**CITY OF PORTLAND, MAINE  
DEVELOPMENT REVIEW APPLICATION  
PLANNING DEPARTMENT PROCESSING FORM  
DRC Copy**

**Lot # 3 Farmouse Lane**

Project Name/Description

**Approval Conditions of DRC**

Drawing Name: **Site Layout & Utilities Plan**
 Project: **LOT 3 - NORTHGATE FARMS, PORTLAND**

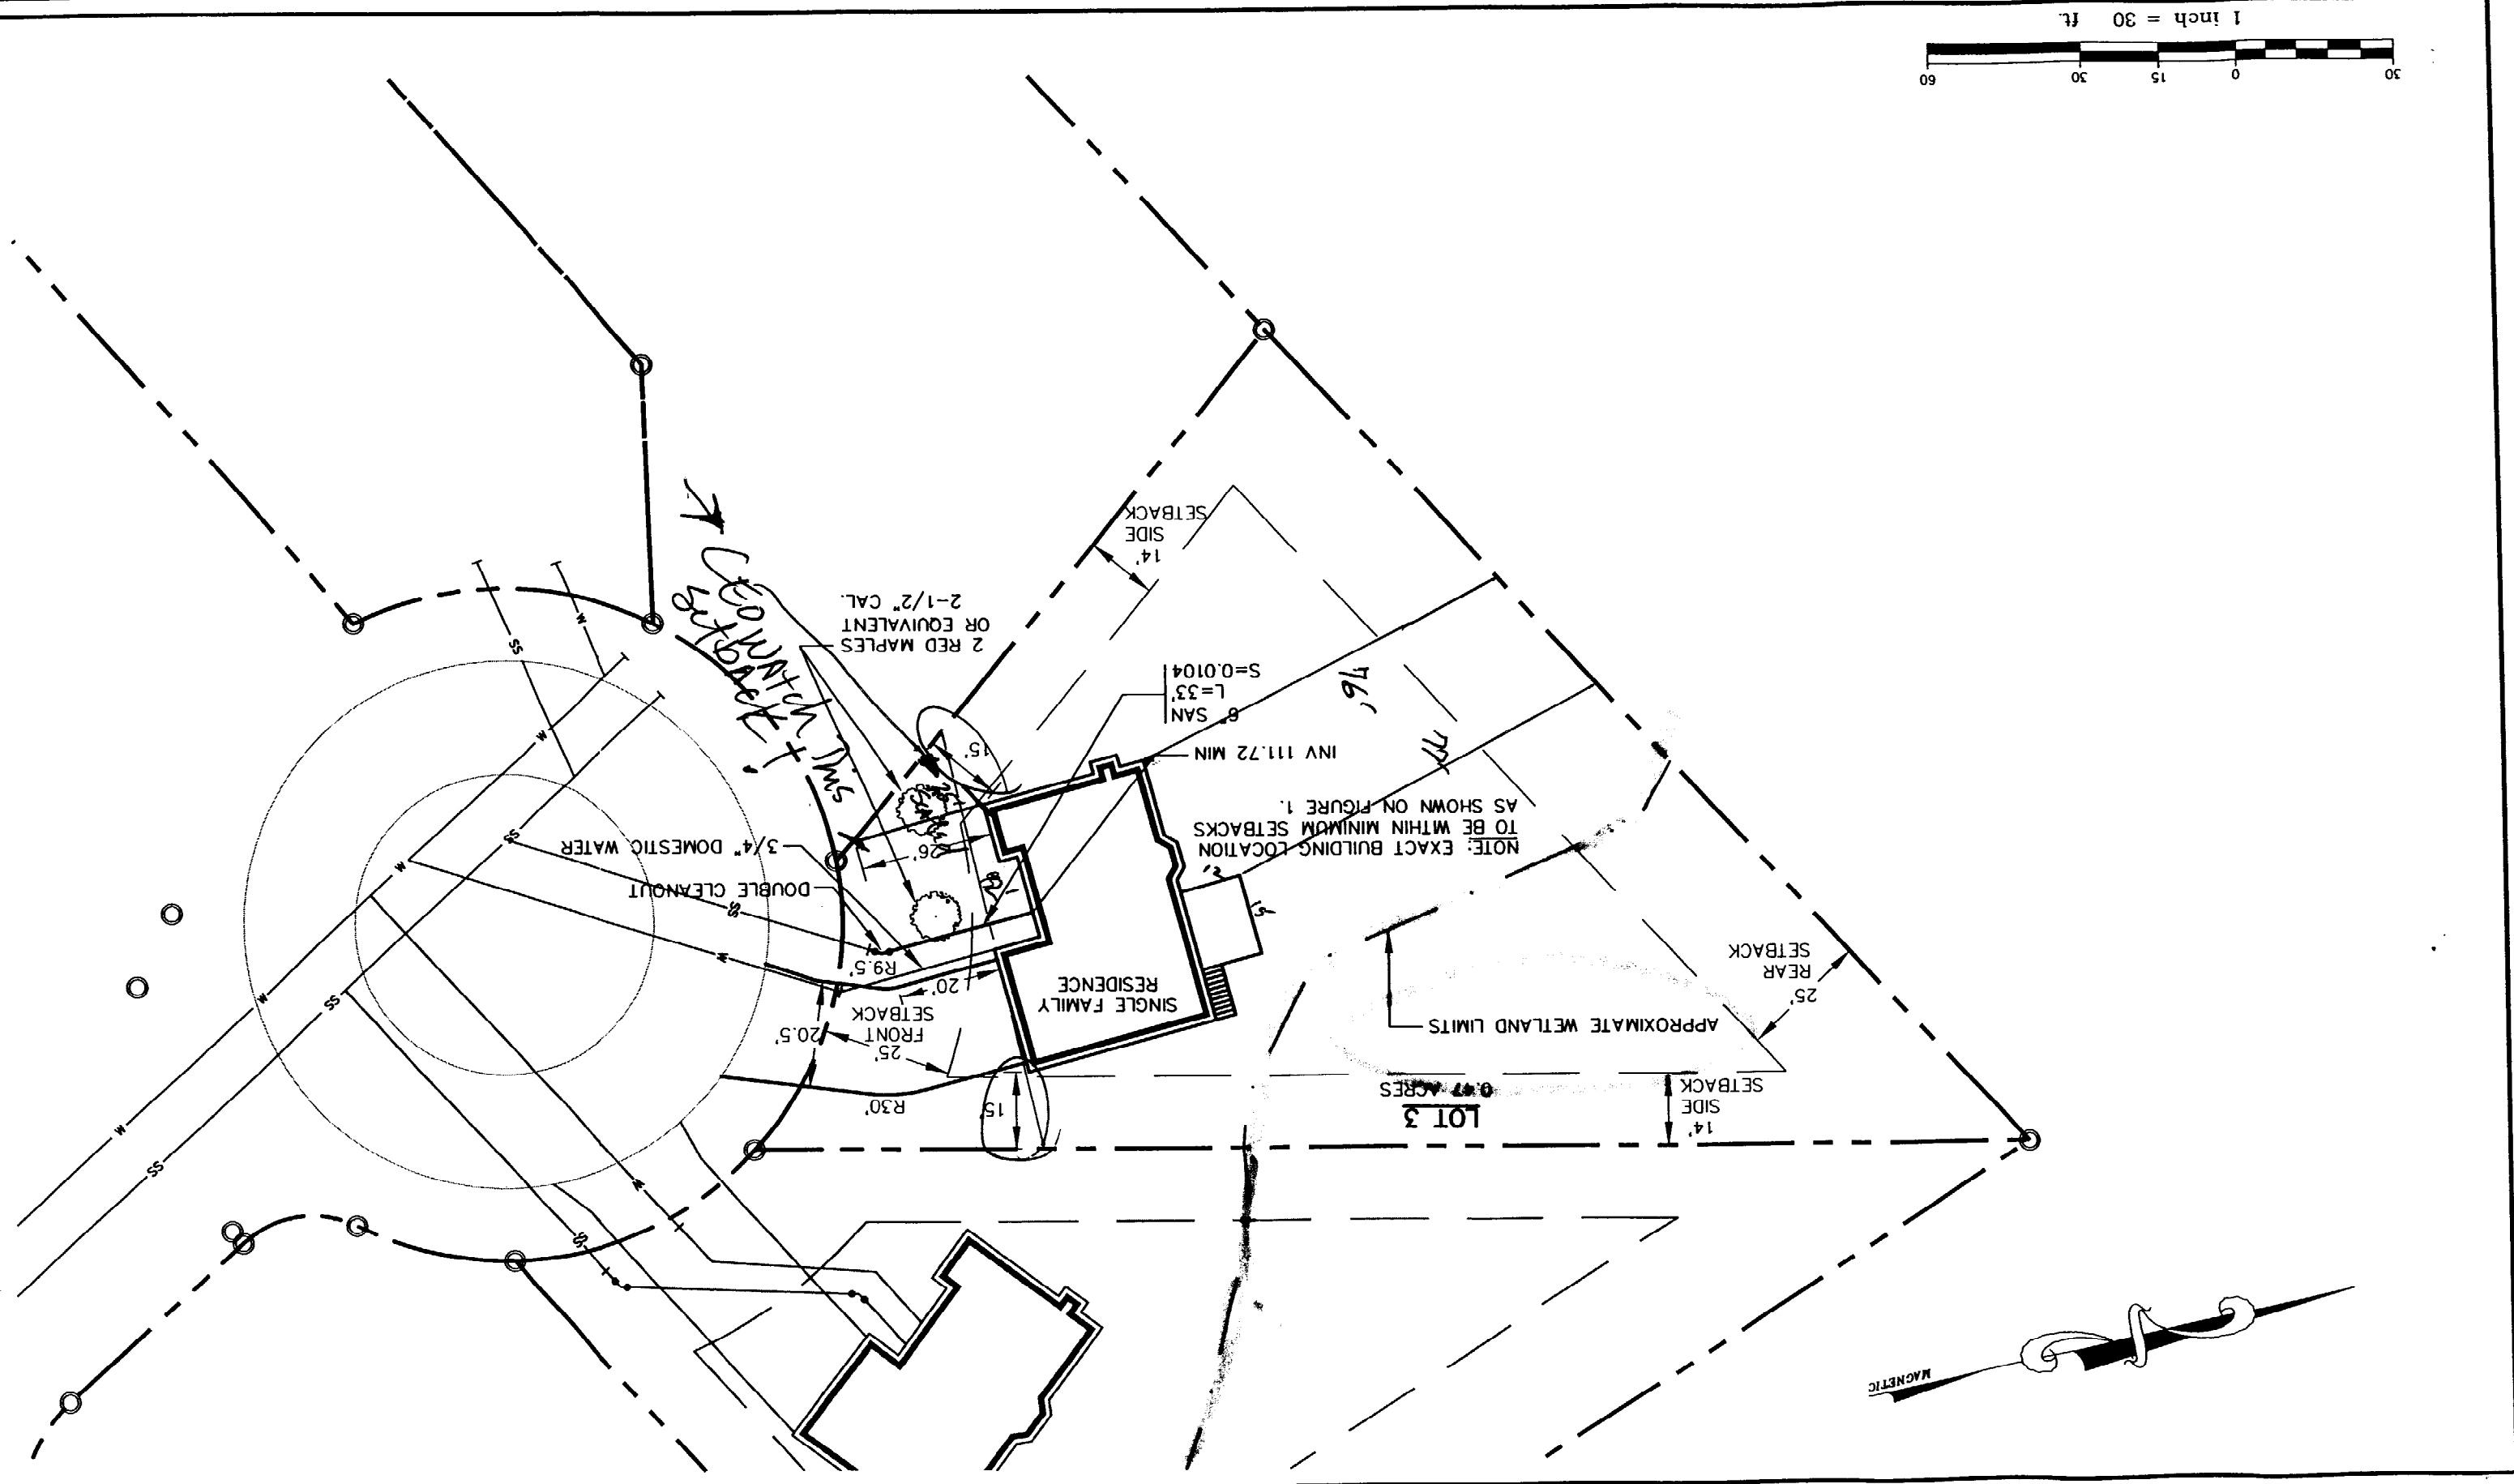
- 1 FINAL GRADING SHALL BE DONE IN ACCORDANCE WITH THE APPROVED SITE PLAN, TO ALLOW DRAINAGE IN THE FRONT YARD TO BE DIRECTED TOWARDS FARM HOUSE LANE.
- 2 Two (2) City of Portland approved species and size trees must be planted on your street frontage prior to issuance of a Certificate of Occupancy.

- 1) Grubbe to Street...
- 2) Move tree long fr. sewer
- 3) show to lot zone
- 4) B.P.E.?
